From: Laura Gibbons
Sent: 05 June 2018 16:08
To: David Easton
Subject: RE: Burndell Road, yapton F/5/18/RES

The surface water scheme is okay in principle, and I will look into it further at DOC.

Fareham Office 444 139 822021		Project: BURDELL ROAD YAPTON	
Designed: JPS	Approved: APT	Approved Date: 06.03.2018	Sheet: DRAINAGE LAYOUT
Drawn: JPS	Scale: 1:250 AT A1	Project No: FA-E-F2300.00	Sheet No.: C300
			Design: P1

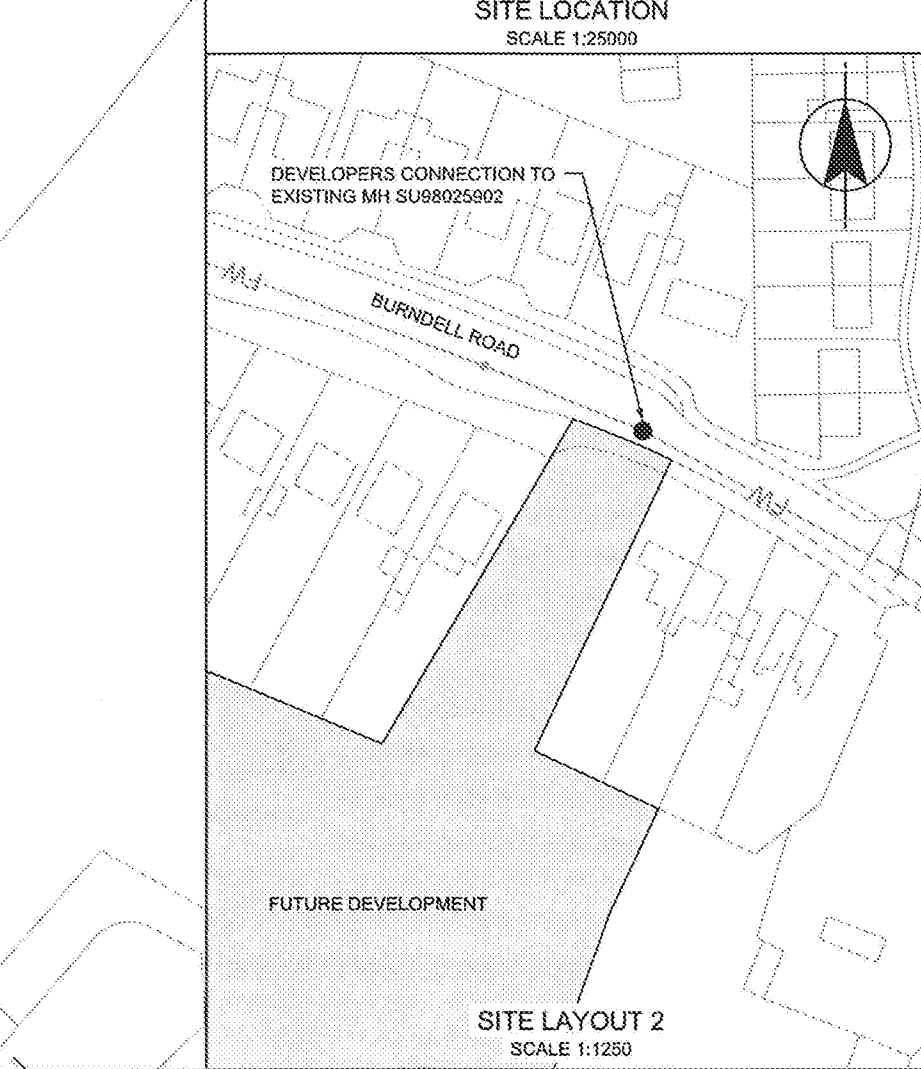
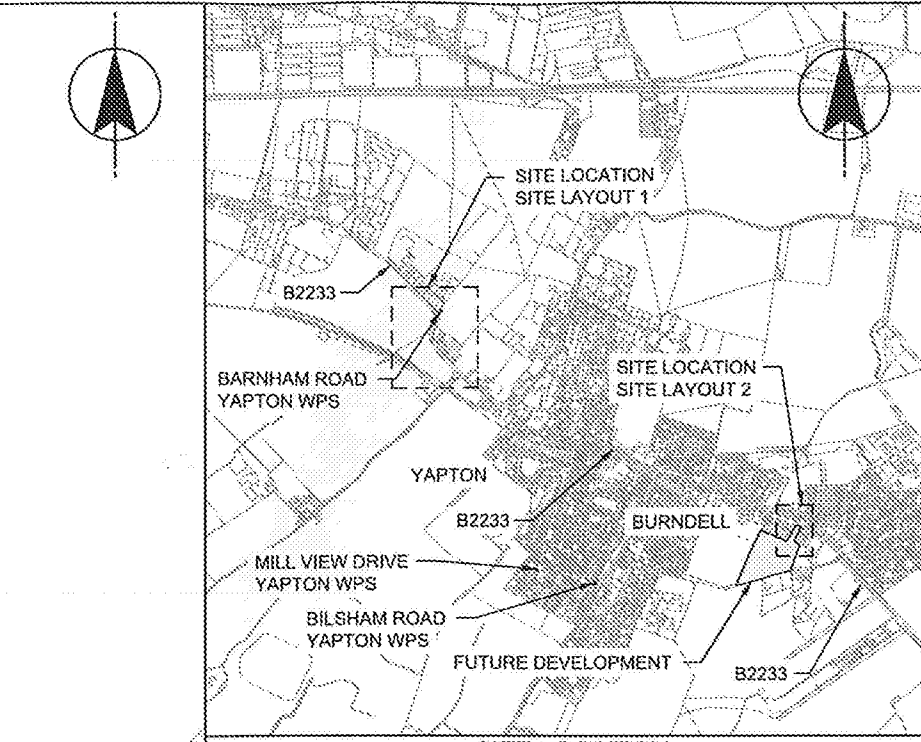
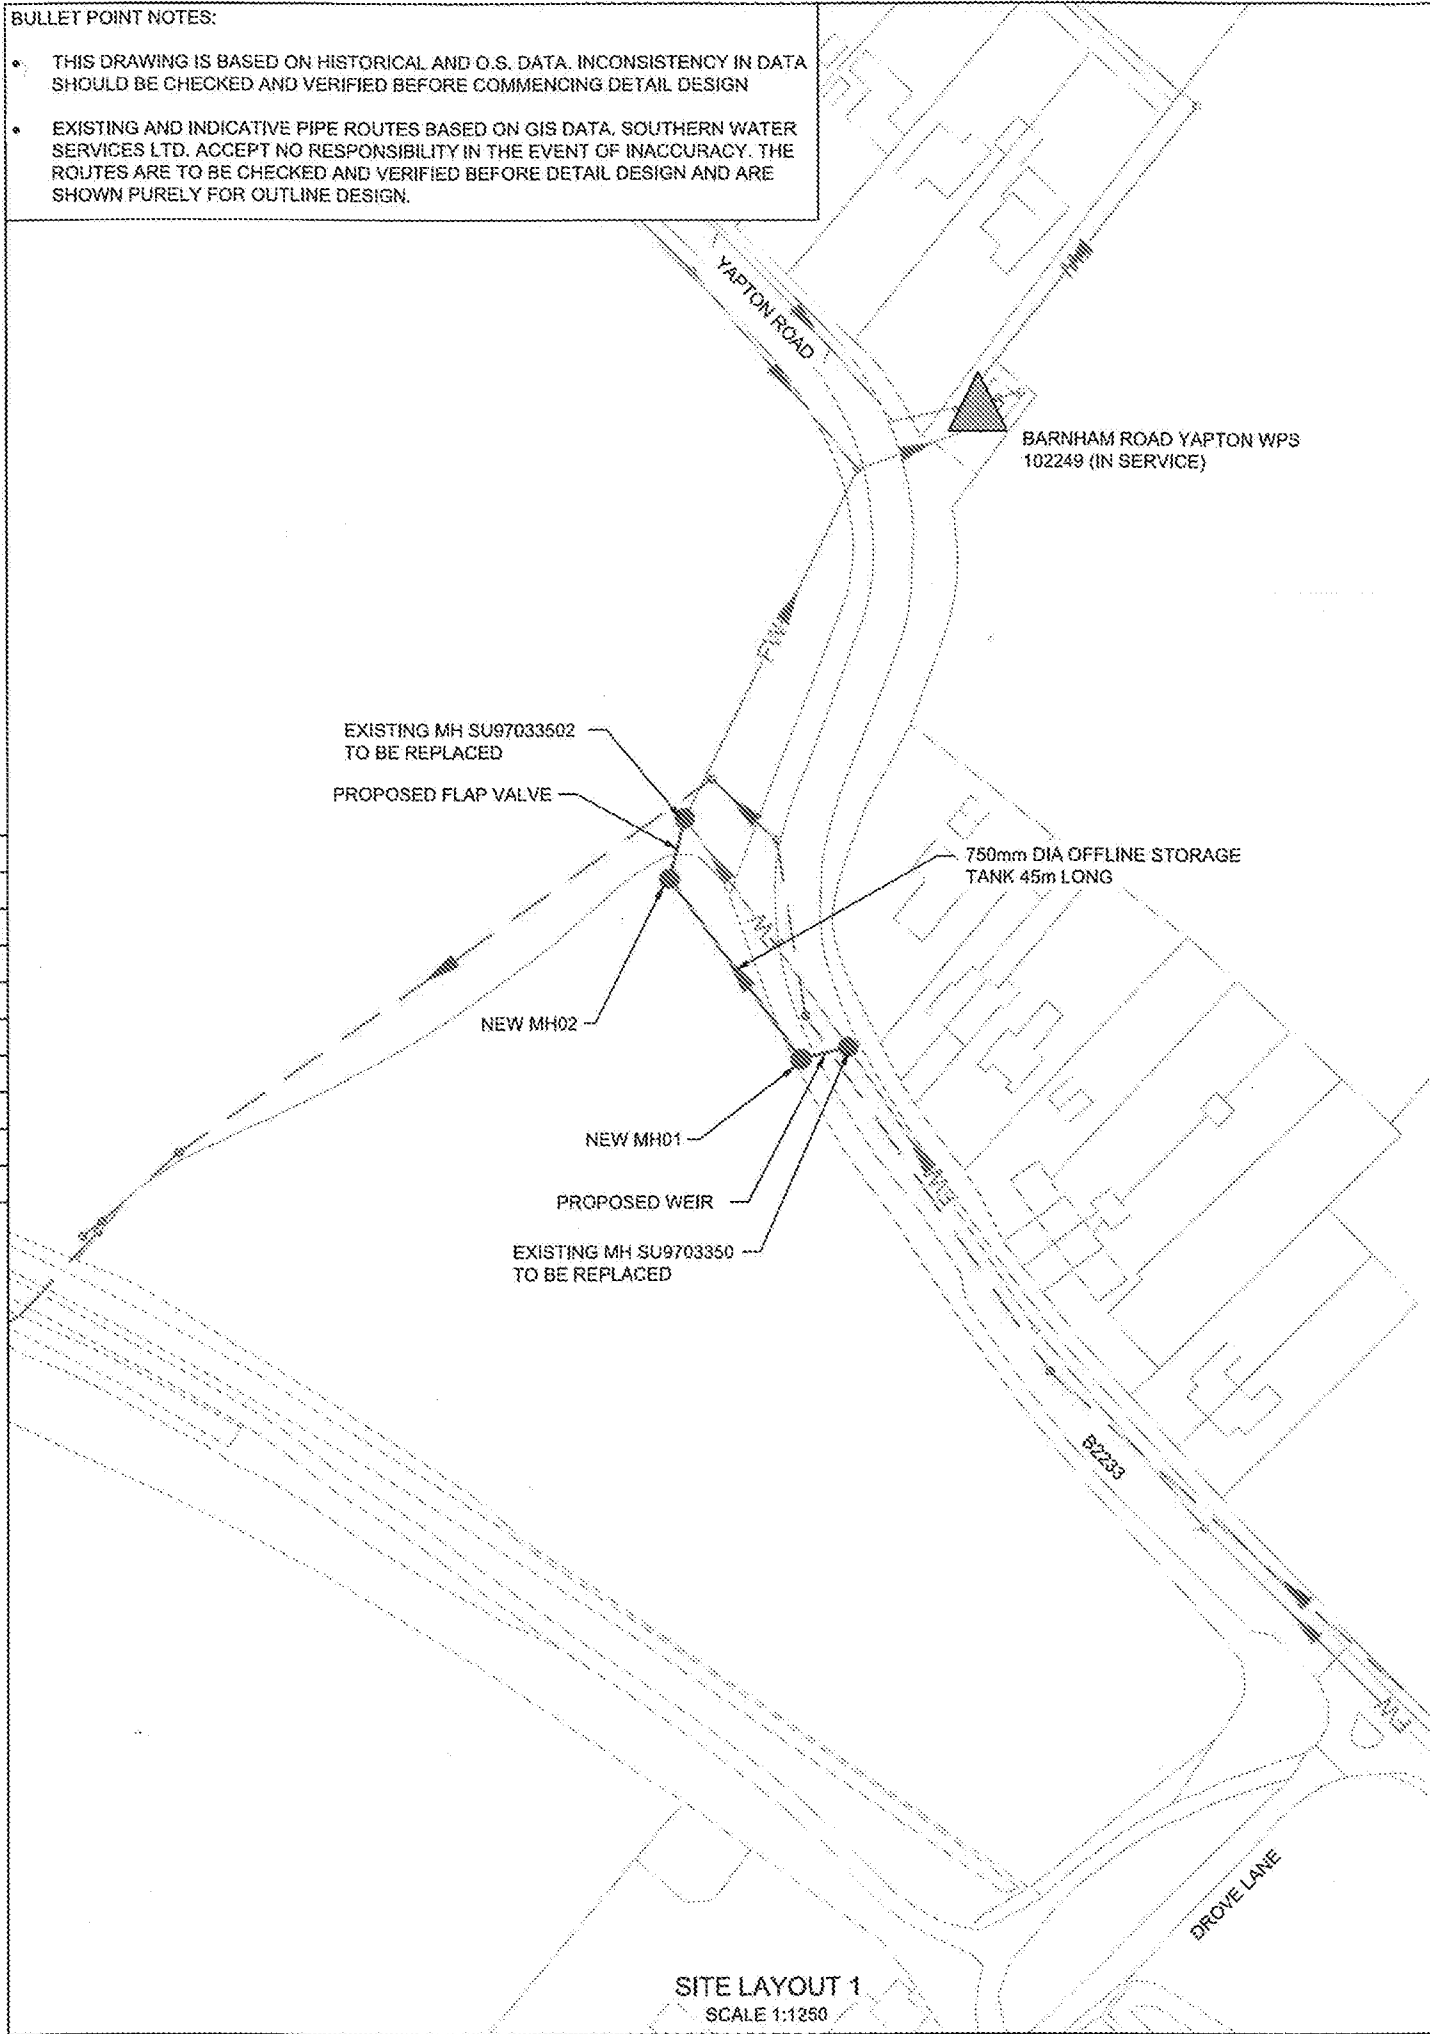
- The use of a tank rather than pond was agreed as the only way forwards, the tank is to be positioned outside of the play area to ensure that it can be accessed for maintenance.
- I also requested the use of more permeable paving so that further treatment of road water could occur. However, southern water does not adopt sewers under permeable pavement, and the developer is therefore not willing to provide these in areas. There are other ways to ensure sufficient treatment occurs from the site, and I will ensure these are pursued at DOC stage.
- The applicant has agreed to complete works to surrounding ditches to remove vegetation and silt and restore them to an appropriate condition.
